From: Paul Cann
Sent: 07 June 2017 16:33
To: Planning.Responses
Subject: RE: Planning Consultation on P/49/17/DOC

Comments in respect to surface water drainage scheme (condition no.4);

Site Address: Church Farm Holiday Village Church Lane Pagham PO21 4NR

Description of Works: Application for approval of matters reserved by conditions imposed under P/84/16/PL relating to conditions 3- Foul water drainage scheme, 4- Surface water drainage scheme, 5- Site safety plan, 7- Implementation of a programme of archaeological work, 8- Golf Course management plan, including mitigation & 9- Details of placement of nesting opportunities for birds.

CLIENT		
BOURNE LEISURE		
PROJECT		
CHURCH FARM GOLF DEVELOPMENT, CHURCH FARM HOLIDAY PARK, PAGHAM, PO21 4NR		
DRAWING TITLE		
CHURCH FARM GOLF DEVELOPMENT DRAINAGE LAYOUT FOR PLANNING 1 OF 2		
PROJECT No.	DRAWING No.	REV.
J-11399	3001	C

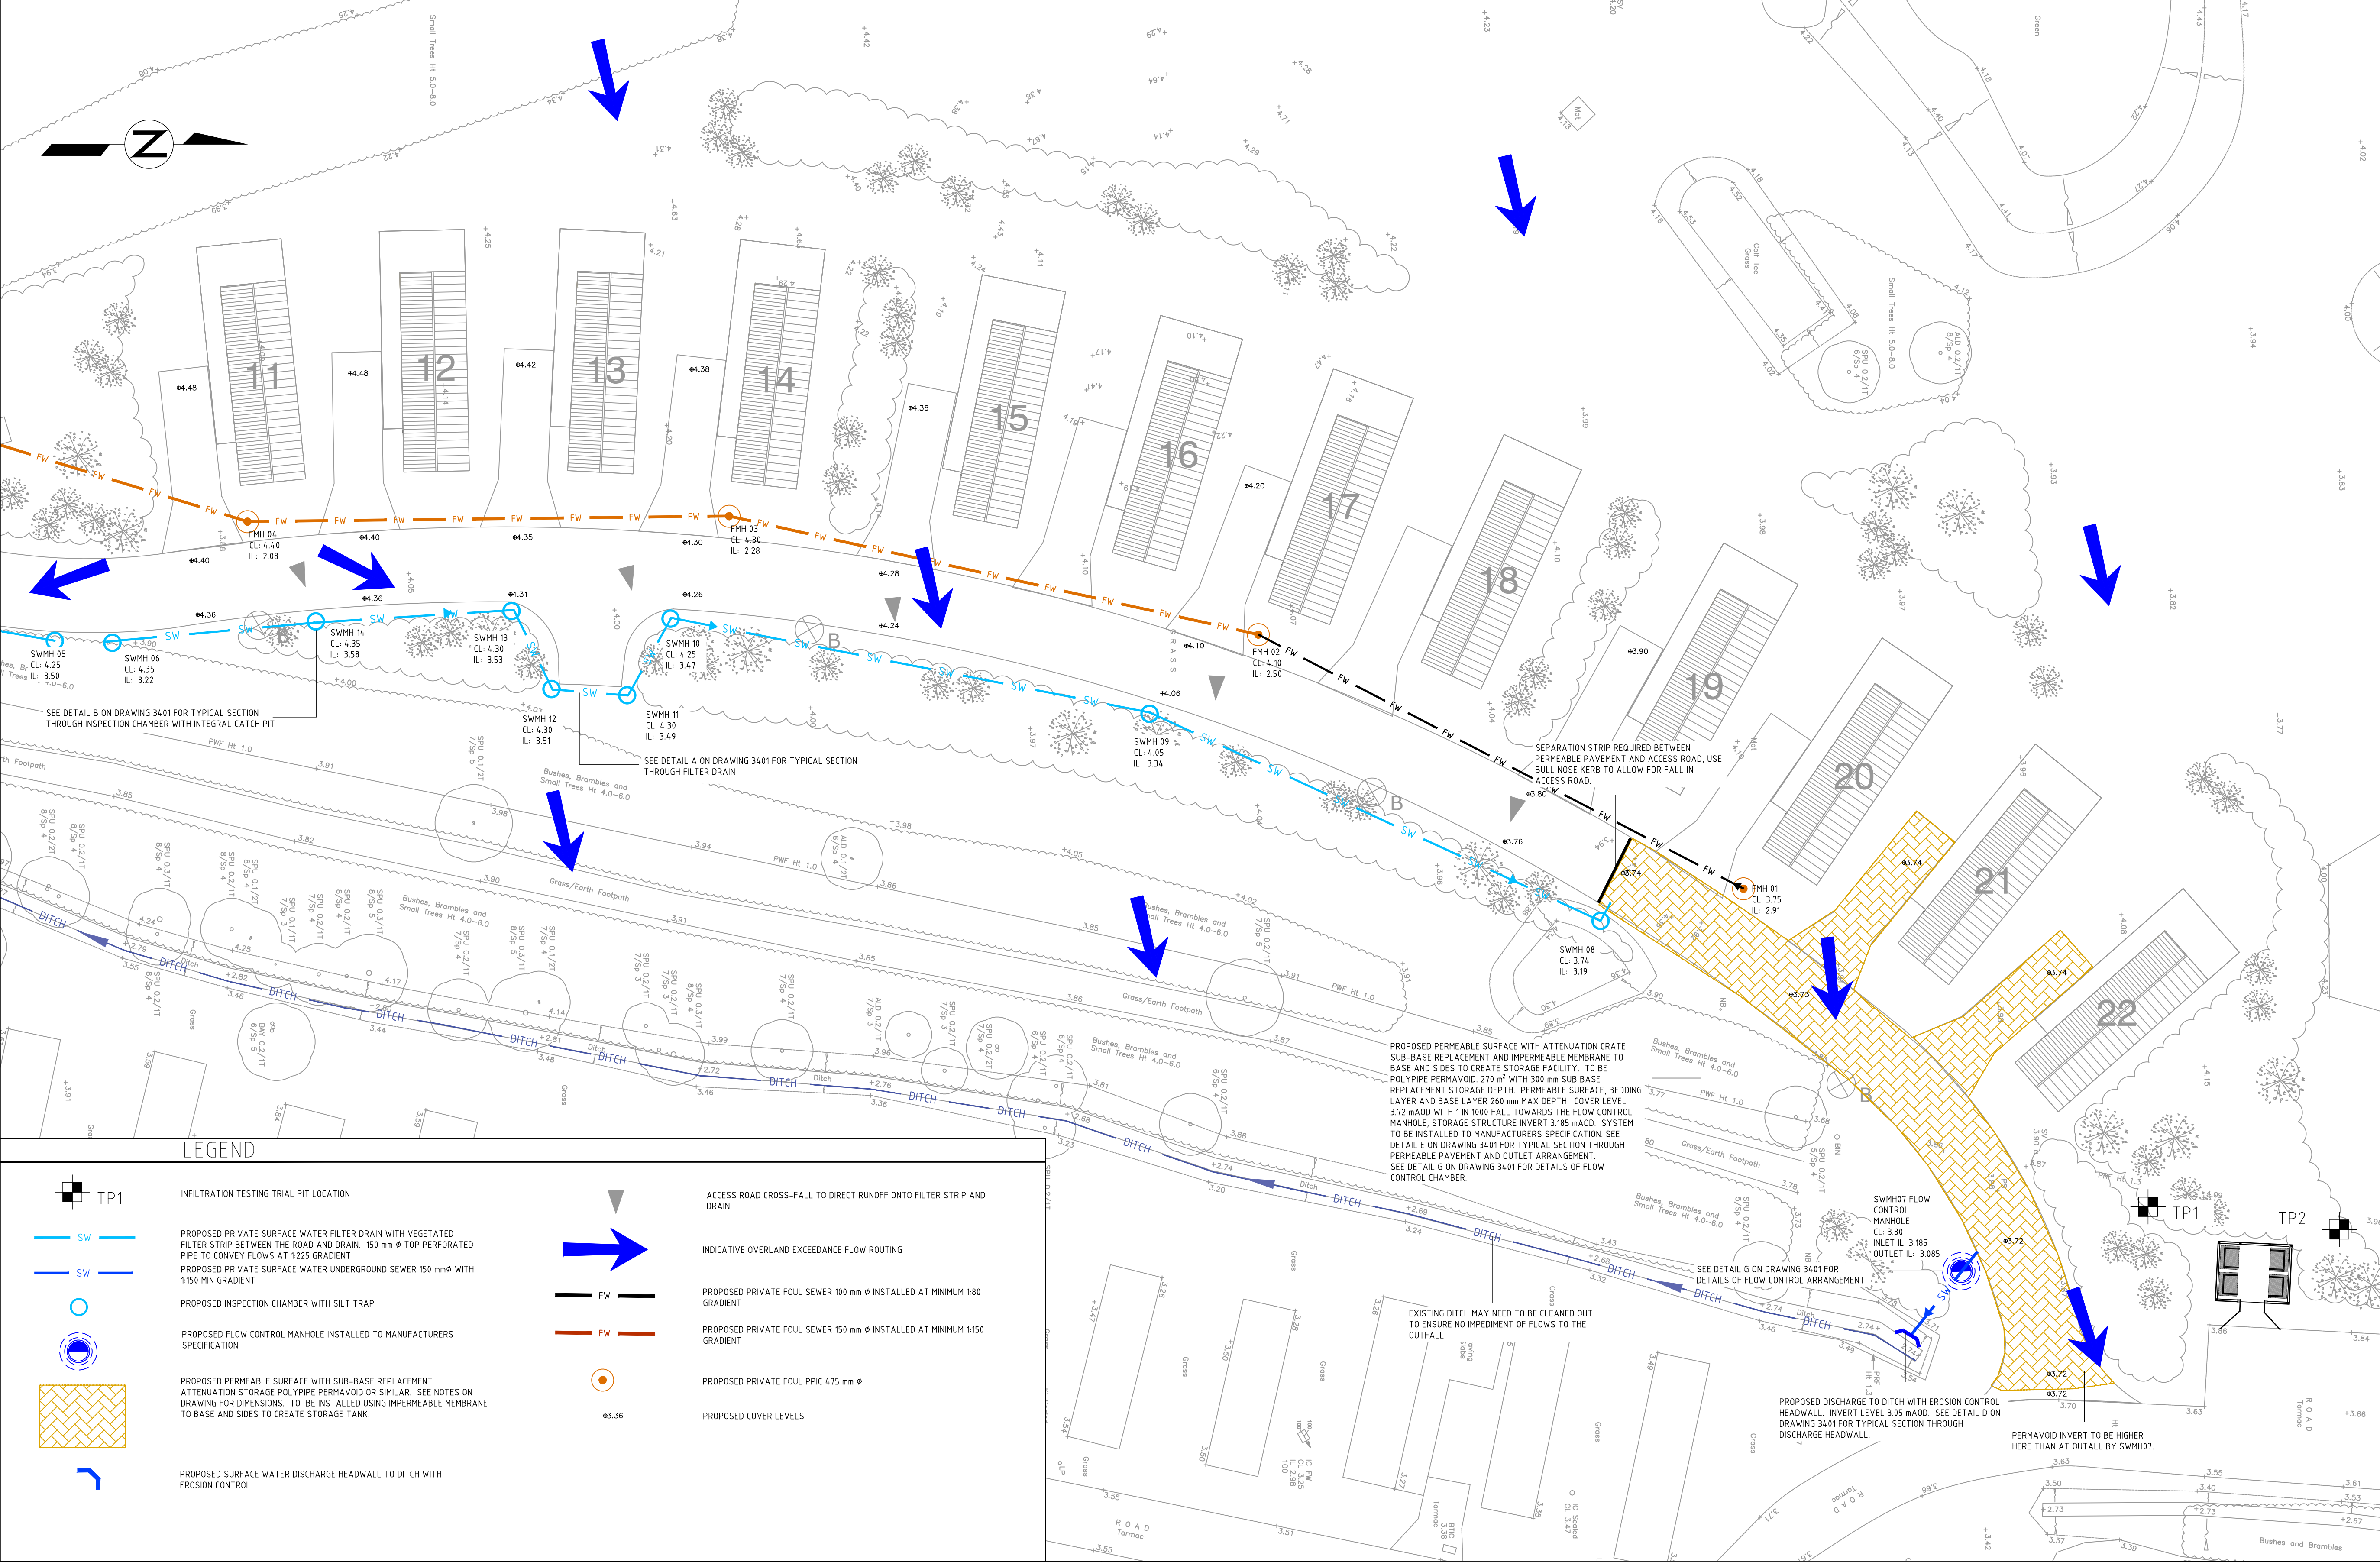
1. All manholes on filter drain to contain silt traps. Additional manhole access required. I.e. on heads of each system/at all significant changes of direction/at intervals not exceeding 50m.

2. Show link on plan from southern most permeable pavement to control chamber.
3. Investigate invert of southern outlet pipe where it discharges to the ditch, in order to provide as much distance as possible between ditch bed and pipe invert. Re-grading the ditch may be an option if the design cannot be adjusted.

4. Specify levels/gradient of filter drain.
5. Show finished surface levels for access road/permeable paving.
6. Existing ditch may need to be cleaned out to ensure no impediment of flows (add note to drawing).
